# Bramford to Twinstead Reinforcement

**Document 8.9.5 (B): Temporary and Permanent Access Technical Note  
– Suffolk County Council**

**Final Issue B  
February 2024**

Drawing title: **AB-AP5
Proposed Visibility Splay
Concept Design
Sheet 1 of 1**

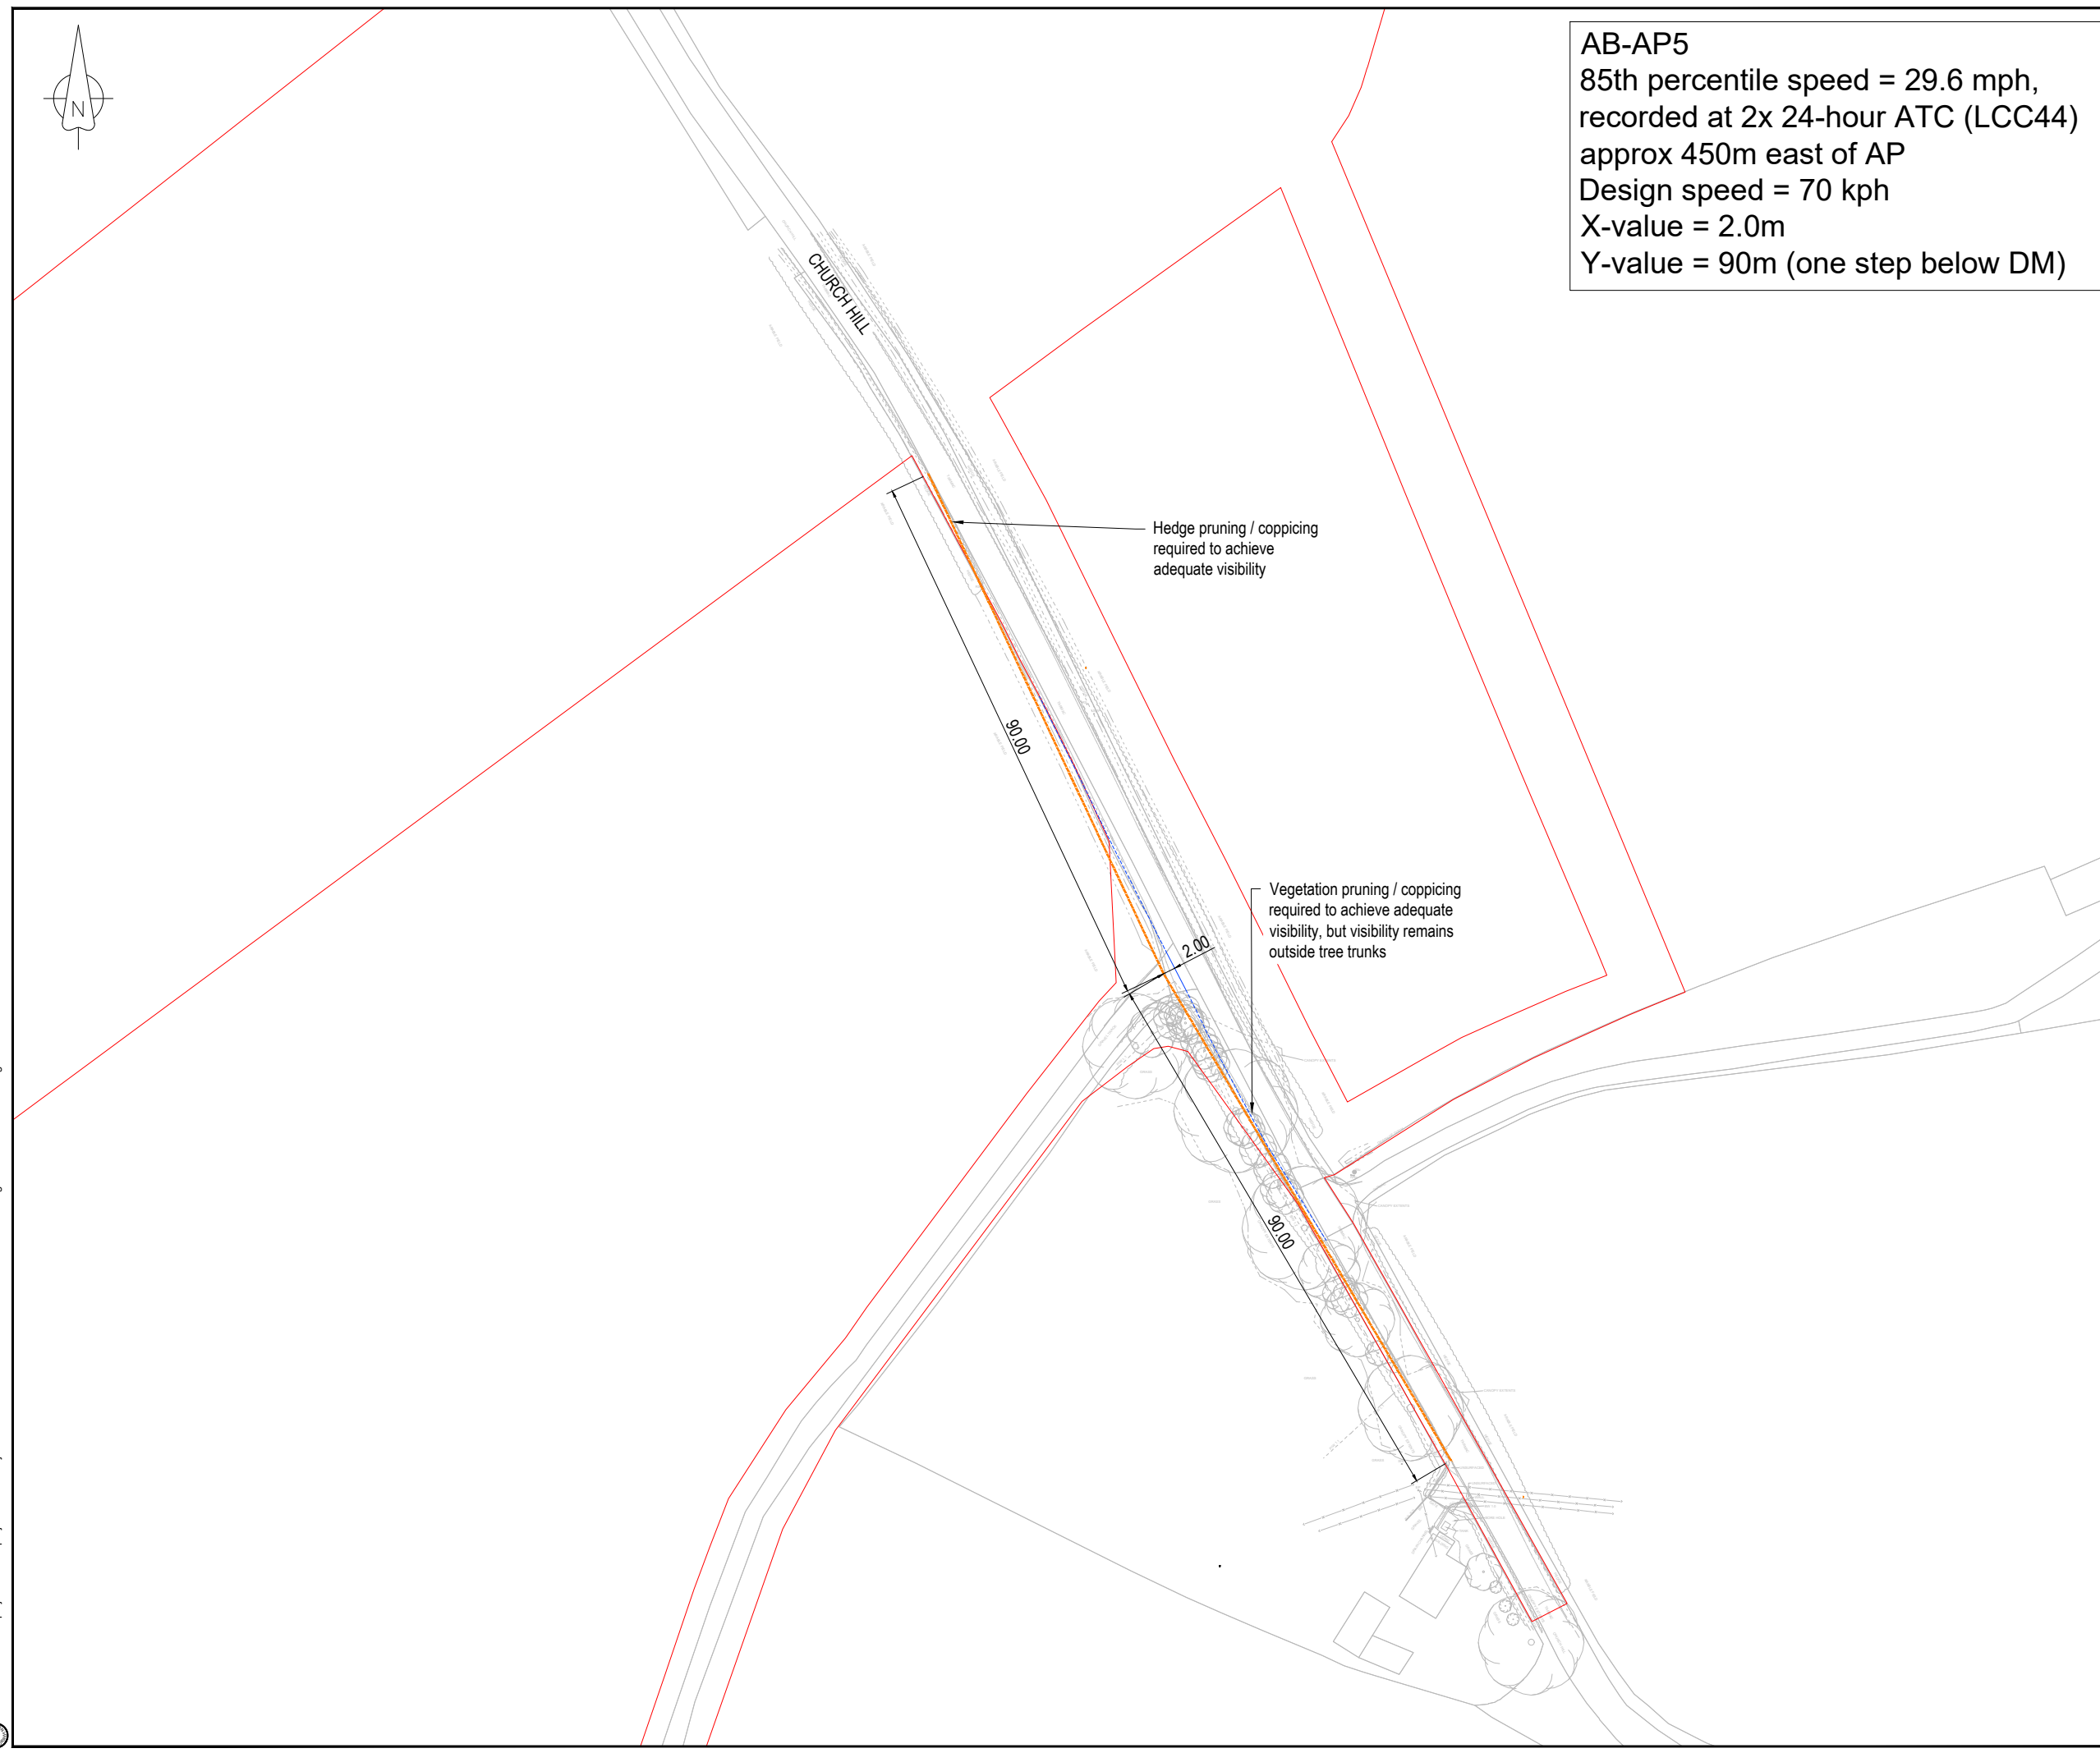
- 2.1.3 AB-AP5 is located north of a bend in the road, which is considered likely to reduce vehicle speeds at the access point and means that visibility to the south of the access point is limited primarily by the curvature in the road rather than by vegetation. The Applicant has drawn a visibility splay based on nearby traffic survey data, indicating that 70kph is the expected upper limit of the 85<sup>th</sup> percentile design speed, yielding a y-value, or distance along the major route of 90m (one step below the desirable minimum stopping sight distance). The Applicant has also considered the National Highways Design Manual for Roads and Bridges (DMRB) CD 123 – Geometric design of at-grade priority and signal-controlled junctions cl. 3.8, and proposes a x-distance of 2m which is appropriate for direct accesses. The x-distance is the distance away from the carriageway edge where the viewpoint of a driver of an emerging vehicle is positioned.

2.1.5 The visibility splay shown in Appendix A requires the coppicing and pruning of vegetation within the functional highway to achieve the dimensions set out above, but the topographic survey has shown that the visibility splay does not interact with any surveyed tree trunks. Speed surveys are being carried out in January 2024 to confirm that the 70kph 85<sup>th</sup> percentile assumption is appropriate. Assuming that the speed surveys confirm assumptions to date, the visibility splays shown in Appendix A are considered appropriate. If the speed surveys show greater speeds than expected, the visibility splay shown would be revisited to determine whether a greater splay would be required or an alternative mechanism introduced to deliver an appropriate access.

~~2.1.8 The recent speed survey has revealed that the design speed based on the 85<sup>th</sup> percentile is 60kph, which is lower than the design speed assumed for the sketch in Appendix A. sign at application. For a design speed of 60kph, 90m is considered the desirable minimum stopping sight distance. Therefore, the survey confirmed that the approach taken in Appendix A is appropriate and no modifications are necessary it is not required to modify the to the visibility splay considered in the concept design.~~

D-DAP1
 85th percentile speed = 27.7 mph, recorded
 at 2x 24-hour ATC on Rands Road,
 south-west of junction with Overbury Hall
 Road
 Design speed = 50 kph
 X-value = 2.0m
 Y-value = 50m (one step below SSD)

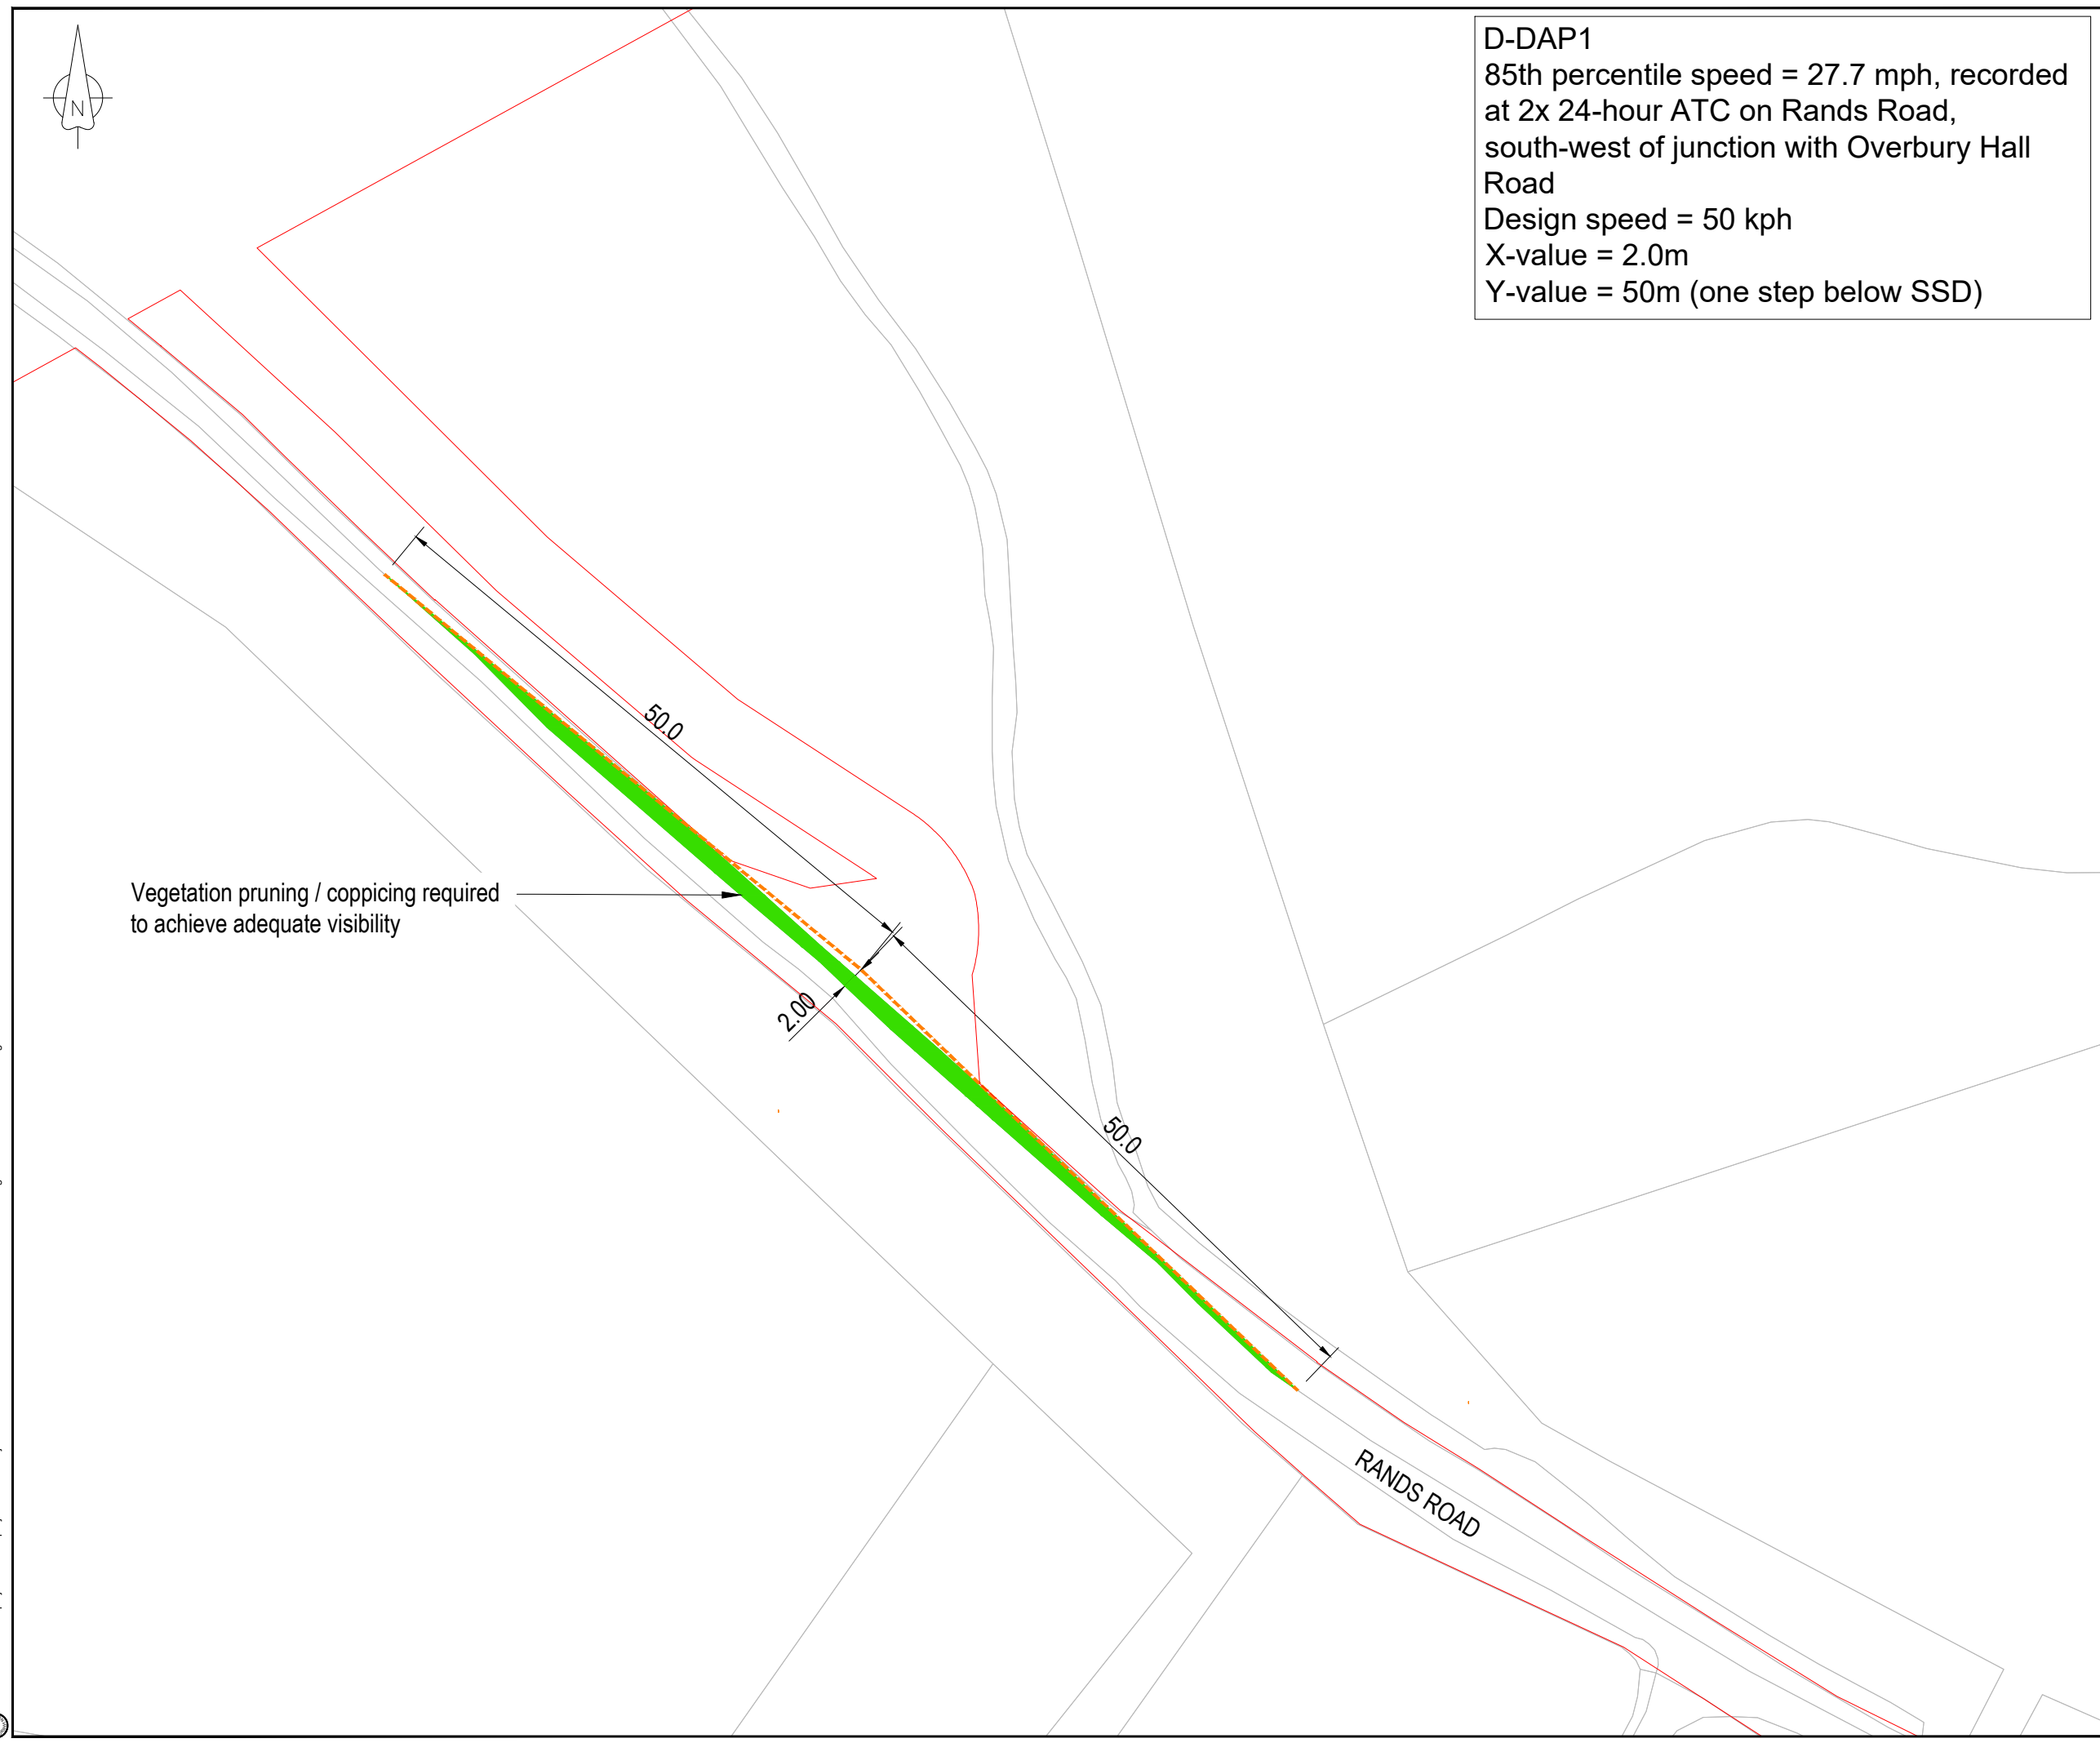
2.7.5 In initial discussion with SCC, it was noted that:

- Rands Road is in effect a single-track road, so any activity is likely to require a temporary closure. Closures might be necessary to prevent a works vehicle or other large vehicle reversing long distances should they meet on the route;
- A mature tree seems likely to require removal to achieve the access bellmouth; and
- A private means of access to the east provides a location where a works vehicle may turn if necessary, with a banksman.

2.7.6 The combination of these aspects means that this access, which is only required for removal of the 132kV line, could have excessive impact on vegetation. Therefore, given the single track width and small scale nature of the work (primarily unloading plant/materials and loading removed apparatus), it may be appropriate to use a short-duration closure to create a more modest area of vegetation removal on a road-field boundary as an access to the adjacent farmland. This would be explored during the detailed design stage, but discussions confirmed that solutions were available. These noted that traffic management measures are likely to provide a more proportionate approach for this lightly-used access, to avoid excessive vegetation removal to provide the full visibility splay.
